## DELEGATED REPORT

**Application Number:** 22/00082/PDCOU

**Application Site:** 17 High Street, Epsom, Surrey,  
KT19, 8DD

**Proposal:** Change of use at second and third floor level from Ancillary Retail (Use Class E) to Dwellinghouses (Use Class C3) to create 1 x 3 bedroom, 4 person residential flat

**PROPOSED**

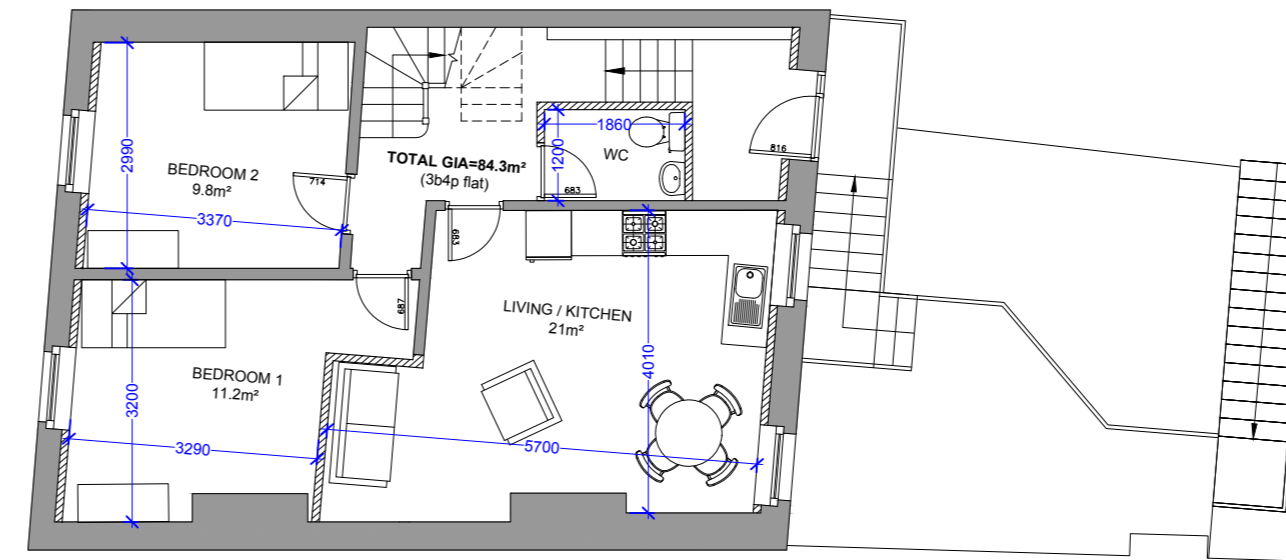
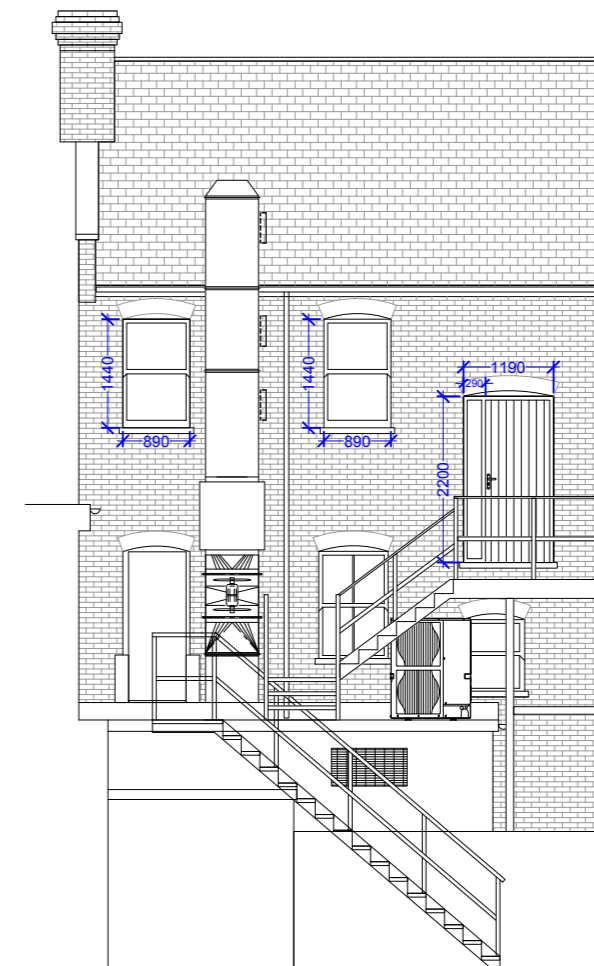
The proposed bedrooms and living/kitchen area would all be served by windows, therefore there is considered to be adequate natural light to all habitable rooms.

The proposed flat would have a GIA of 84.3sqm, just exceeding the minimum internal space standards and therefore providing adequate internal living arrangements.
